Contact: Kate MacDonald
Phone: 02 9228 6435
Fax: 02 9228 6540
Email: kate.macdonald@planning.nsw.gov.au
Our ref: MP10_0171 MOD 3

330 Church Street, Parramatta (MP10_0171 MOD 4)

Attachment 1

SHADOW DIAGRAM - WINTER SOLSTICE (JUNE 21ST) 9.00AM
1:2000 @ A1

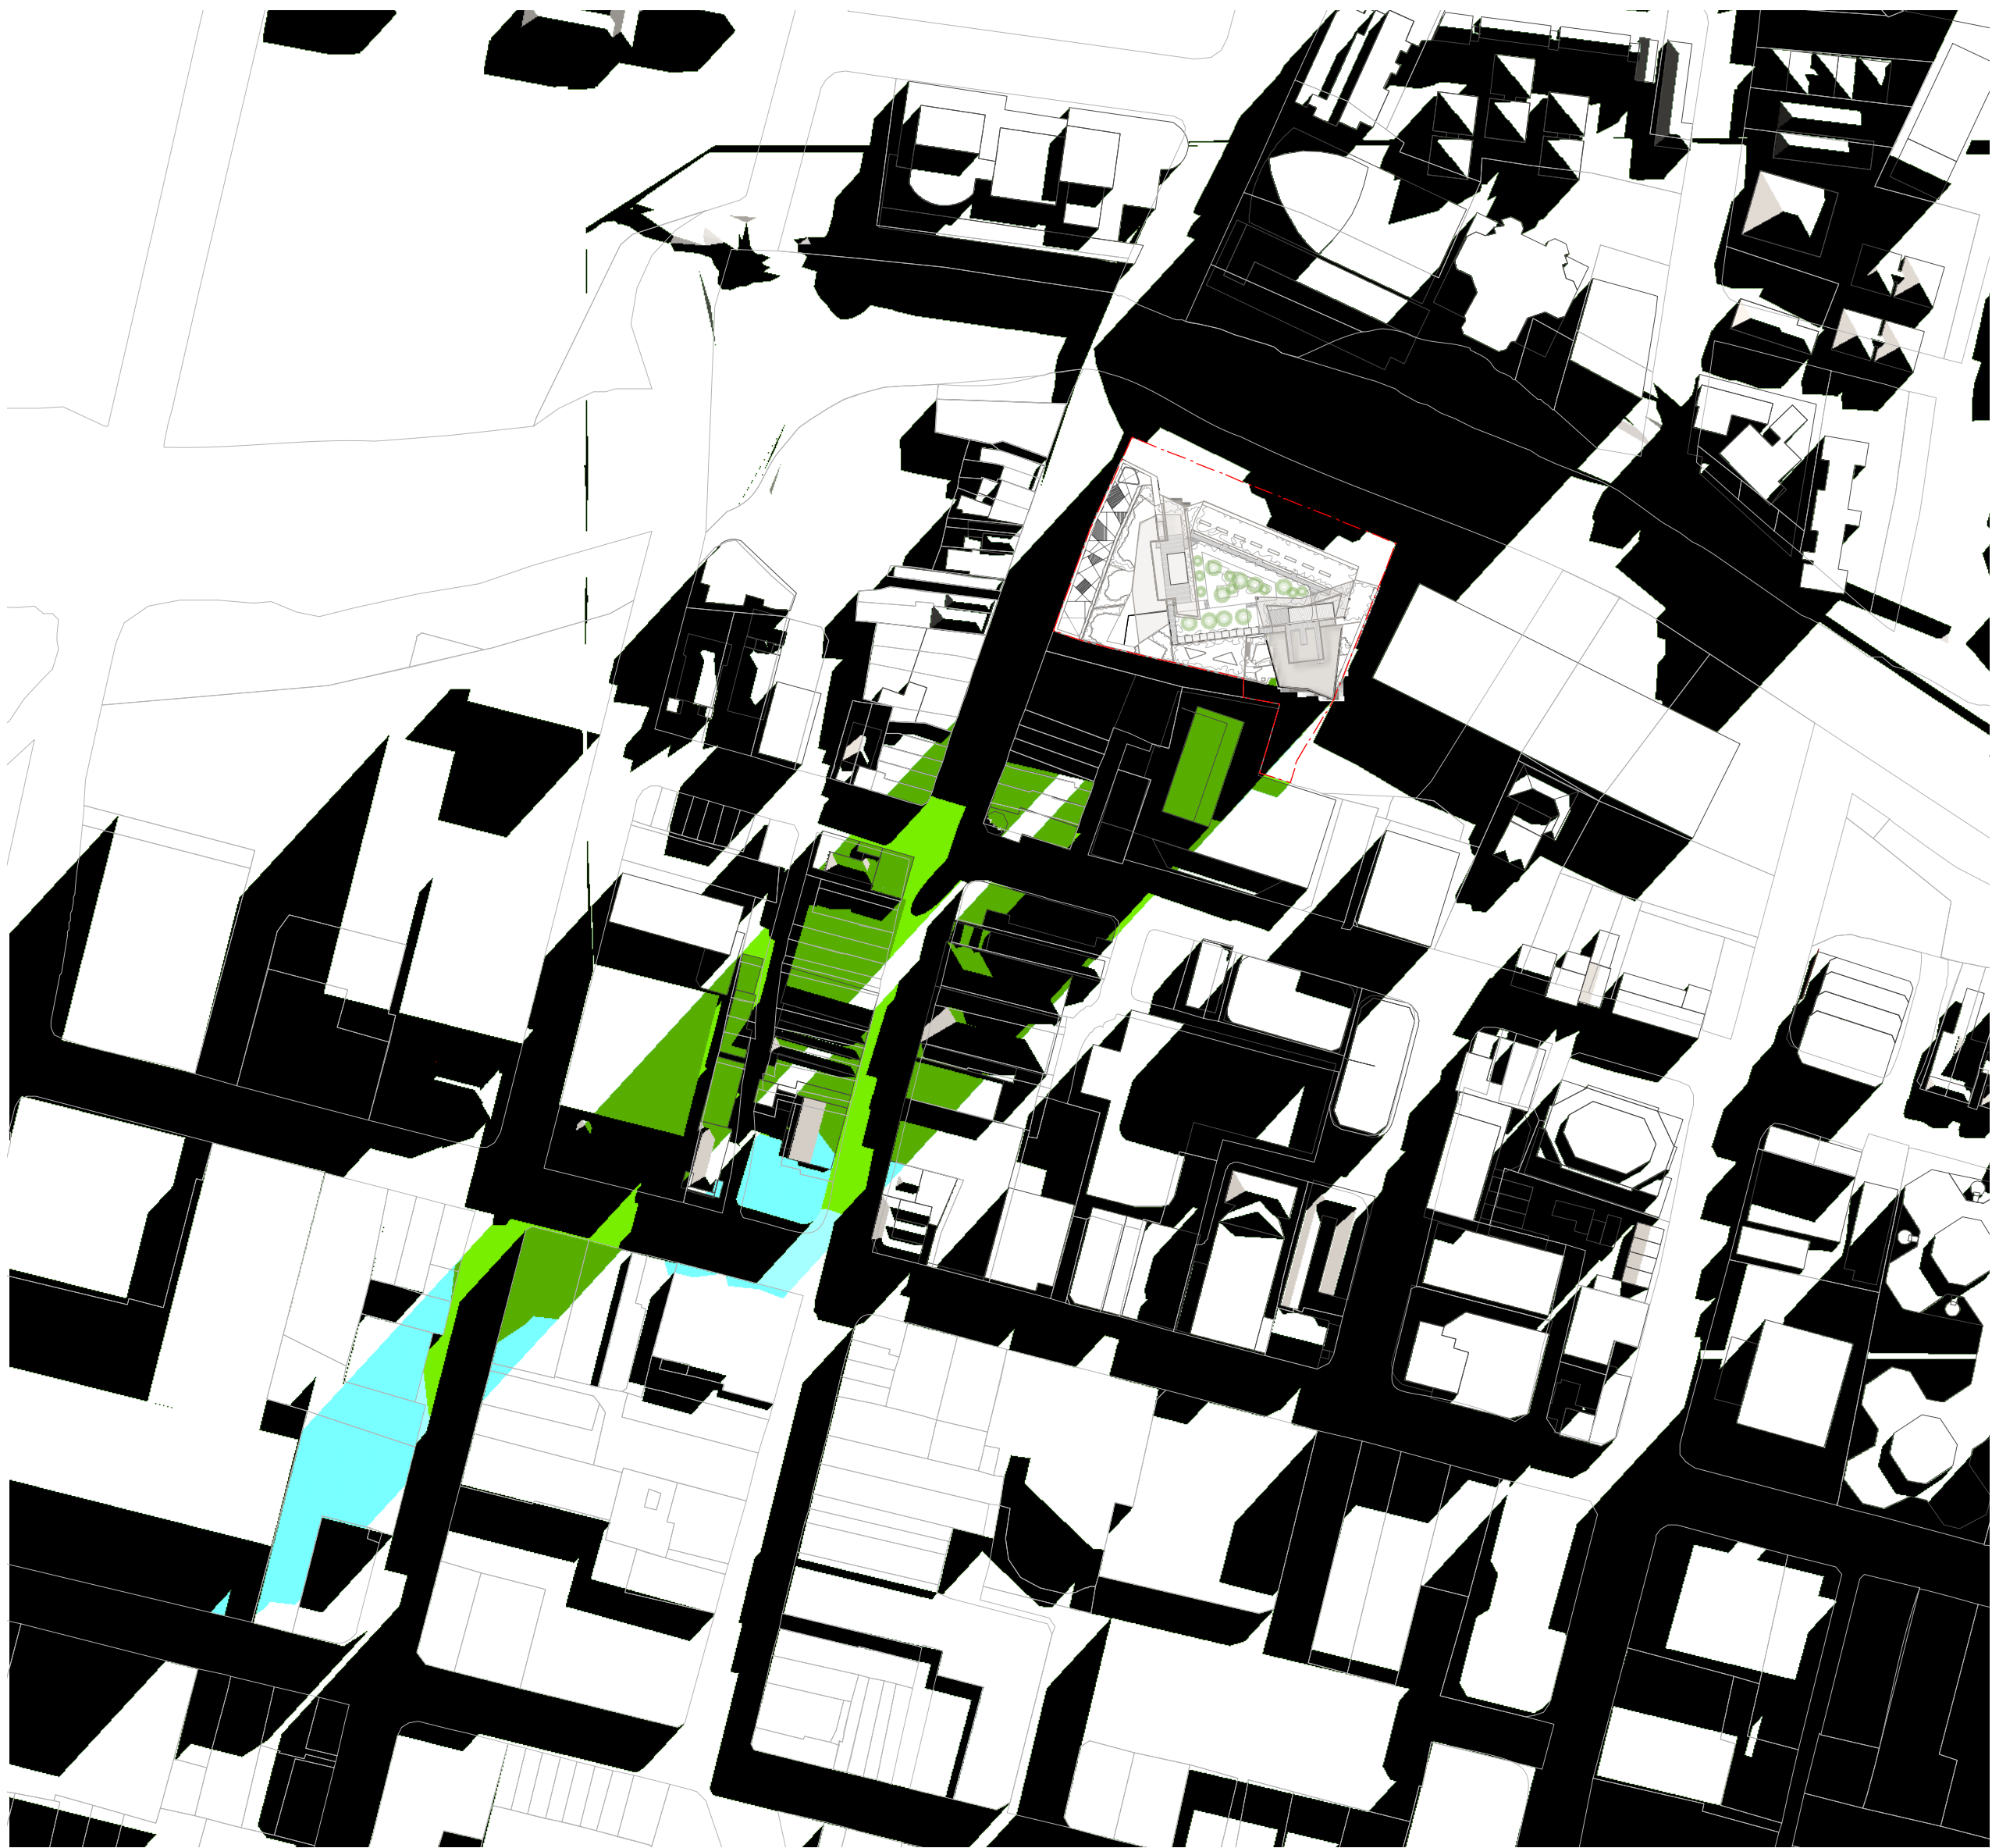
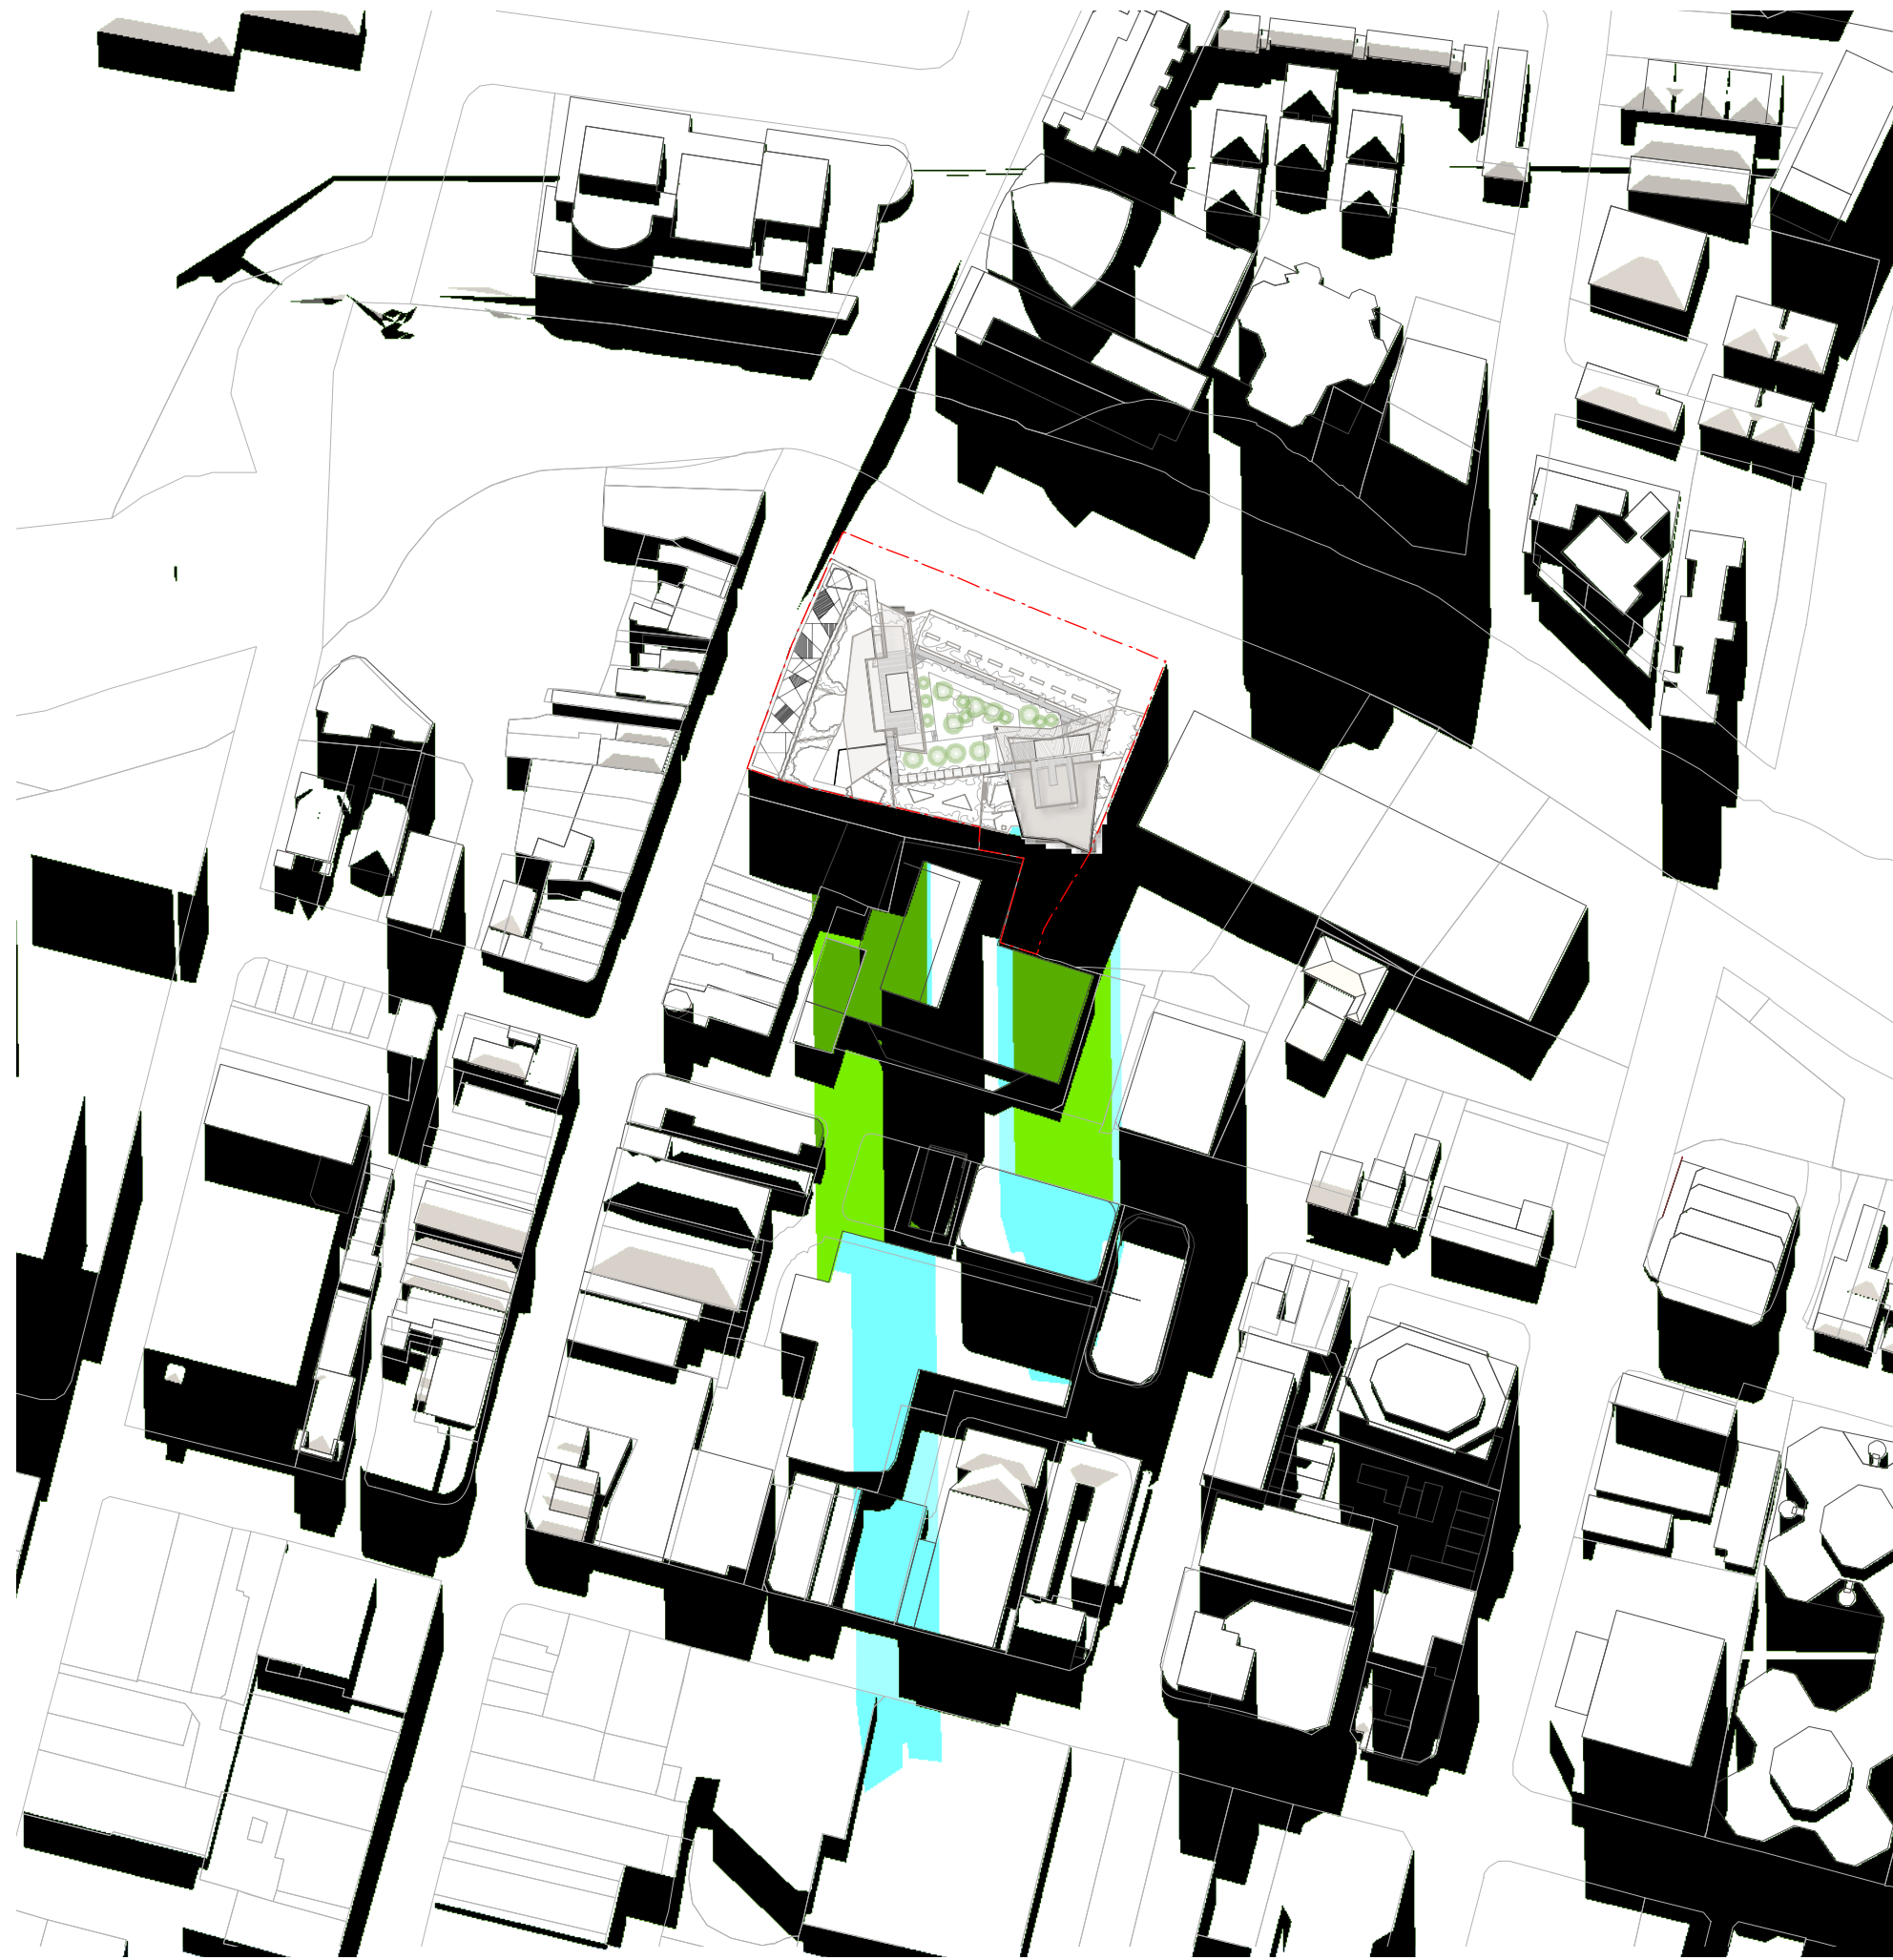
The shadow diagrams must be revised to reflect any revisions to the proposed building.
